ENG-SF21032-R2-FDR.pdf Markup Summary

STERLING RANCH FILING 3 WATER QUALITY DRAINAGE MAP

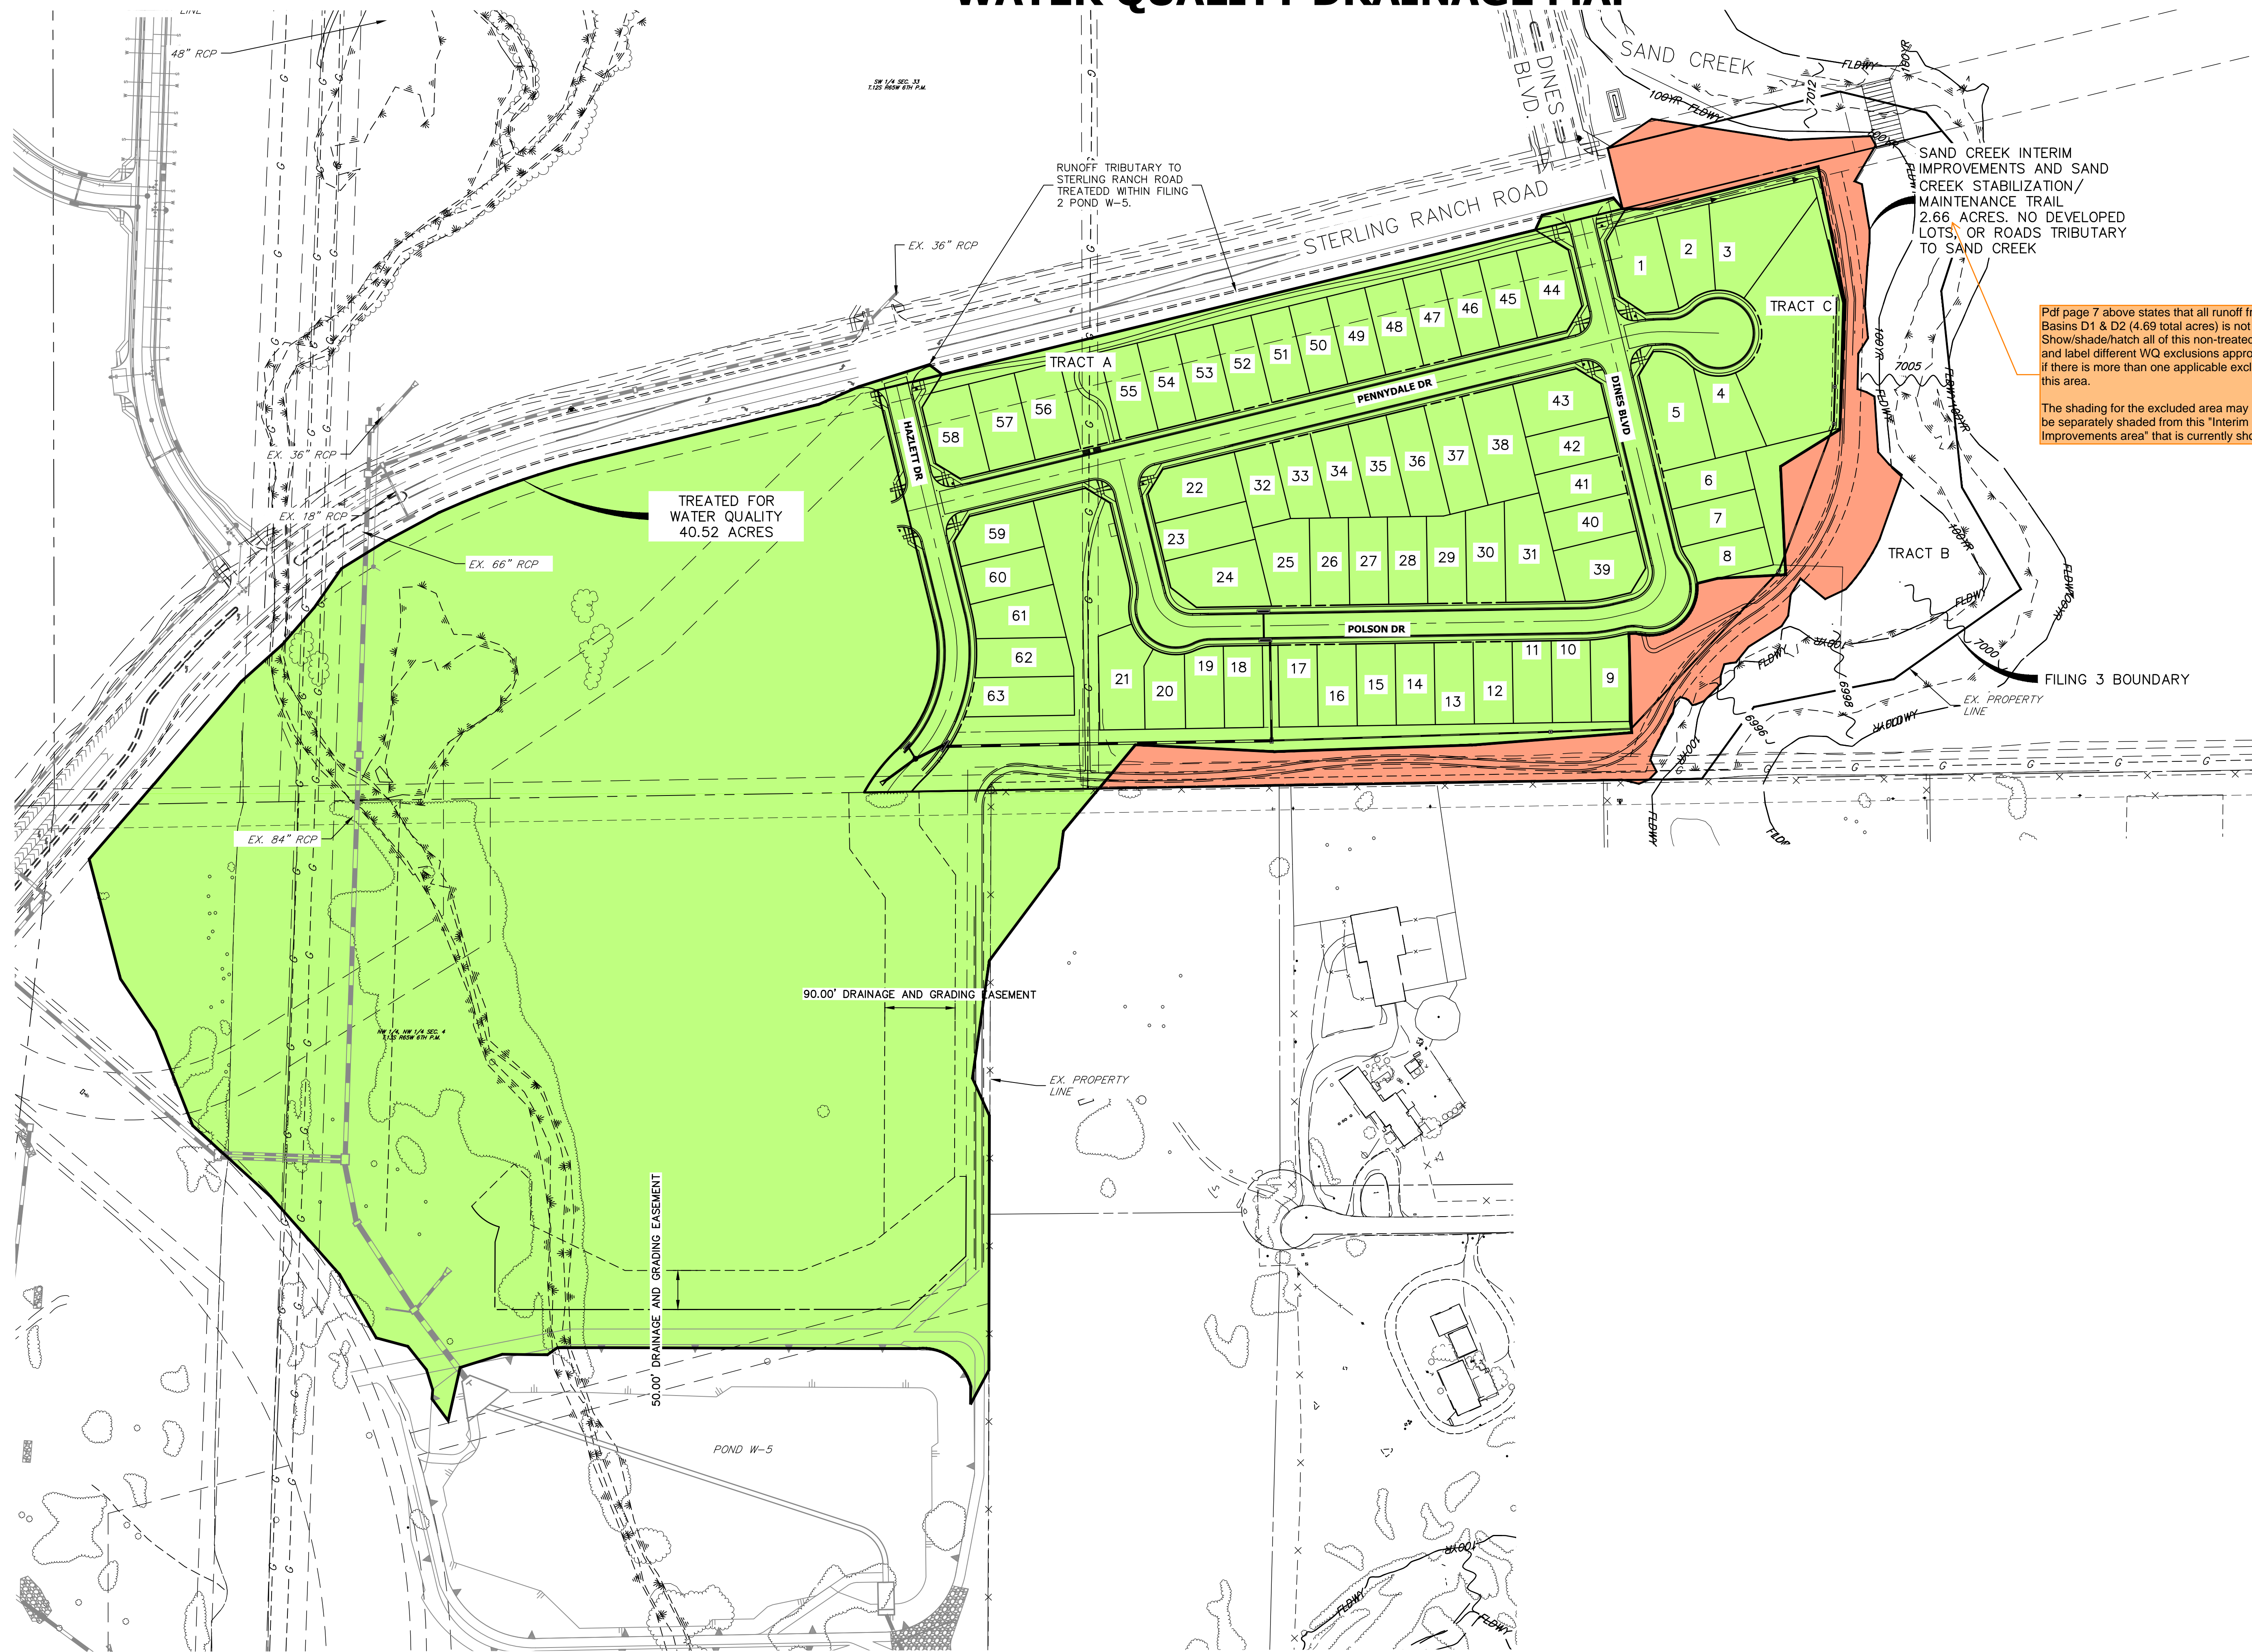
Pdf page 7 above states that all runoff from Basins D1 & D2 (4.69 total acres) is not treated. Show/shade/hatch all of this non-treated area and label different WQ exclusions appropriately if there is more than one applicable exclusion to this area.

The shading for the excluded area may need to be separately shaded from this "Interim Improvements area" that is currently shown.
